PLANNING APPLICATION REPORT**REF NO:** BR/119/09/**LOCATION:** 24 West Street
Bognor Regis**PROPOSAL:** Change of shop to residential (Re-submission following BR/328/08/)**SITE AND SURROUNDINGS**

PROPOSED EAST ELEVATION WEST STREET WINDOWS

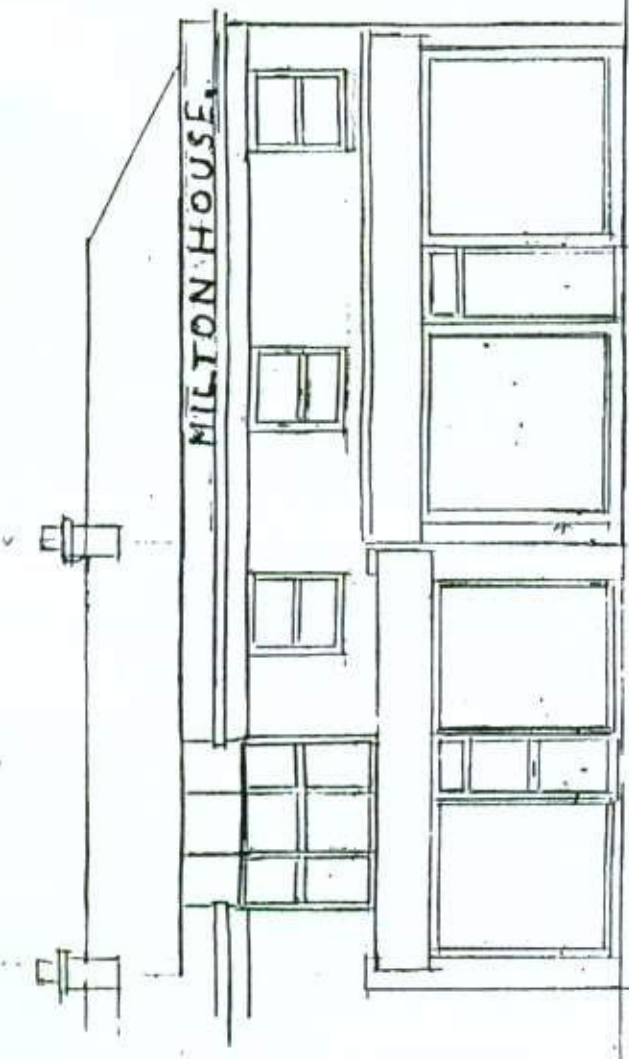
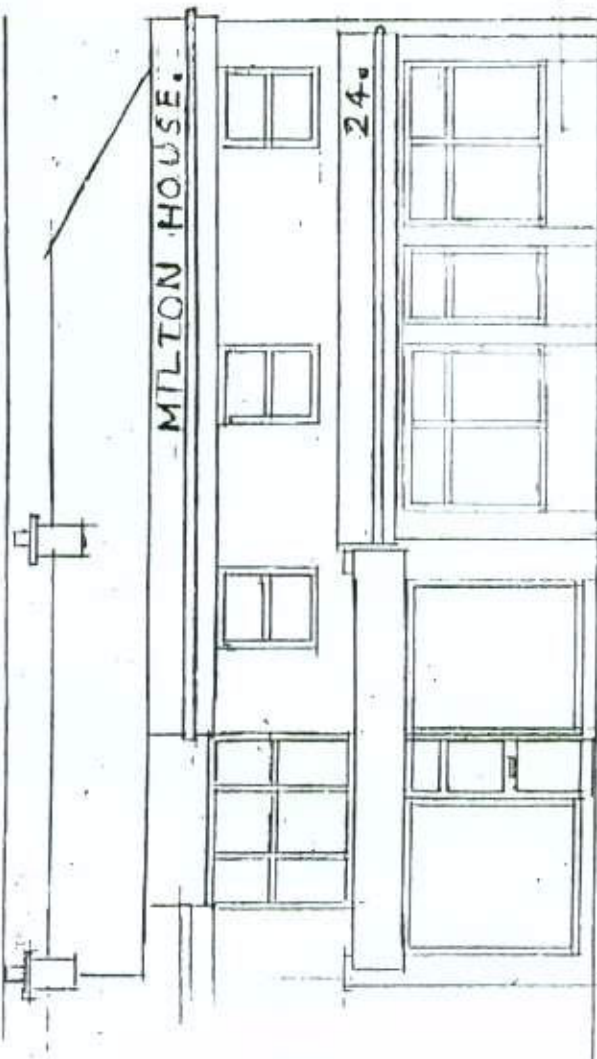
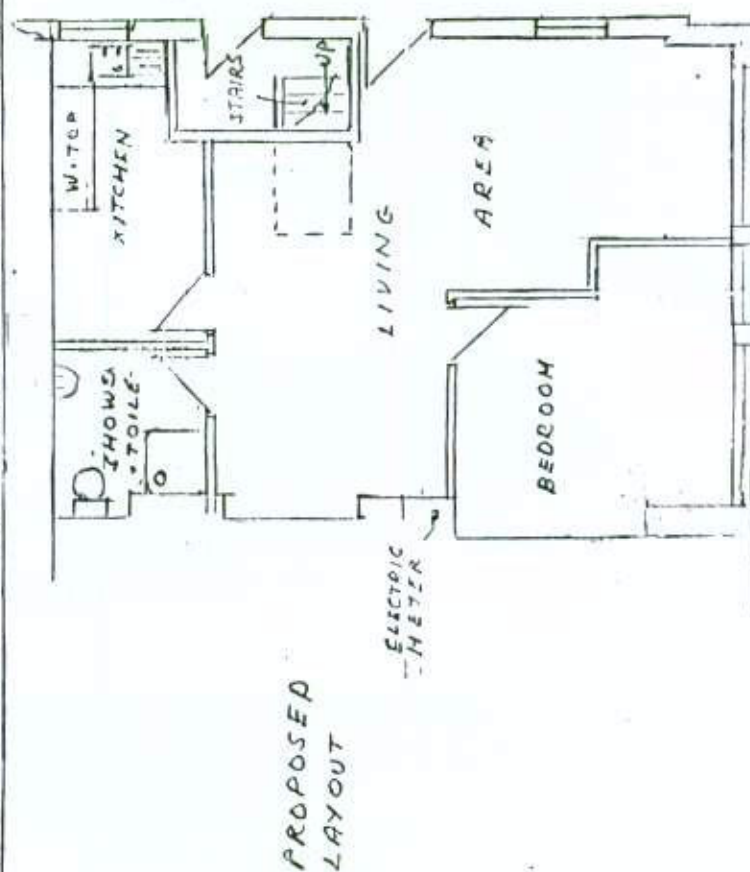
Comment - Quality & finish of new joinery will be critical.

The site is the end terrace of two retail units both of which are currently vacant and visually unattractive. This shop front has undergone previous and unsympathetic alterations. The statement of character for the Steyne and Waterloo Square Conservation Area, contained in the Conservation Area SPG, sees opportunities for improvement/enhancement as being the "restoration of original softwood timber sash or casement windows and doors, shop fronts, etc. where replaced with later, inappropriate features." Whilst the loss of the shop takes away the chance to restore the shop front the proposed residential use provides an opportunity to improve/enhance the conservation area by restoring sash or casement windows and doors. Furthermore, an established feature on this corner location is that it is a significantly glass fronted elevation. This application, unlike its predecessor, proposes to retain a large proportion of glass and thereby retain some of the existing character.

- 3 No development shall be carried out unless and until a schedule of materials and finishes and samples of joinery details and decorative finishes of windows and doors and their surrounds/frames have been submitted to and approved by the Local Planning Authority. The development shall be carried out in accordance with the approved details.
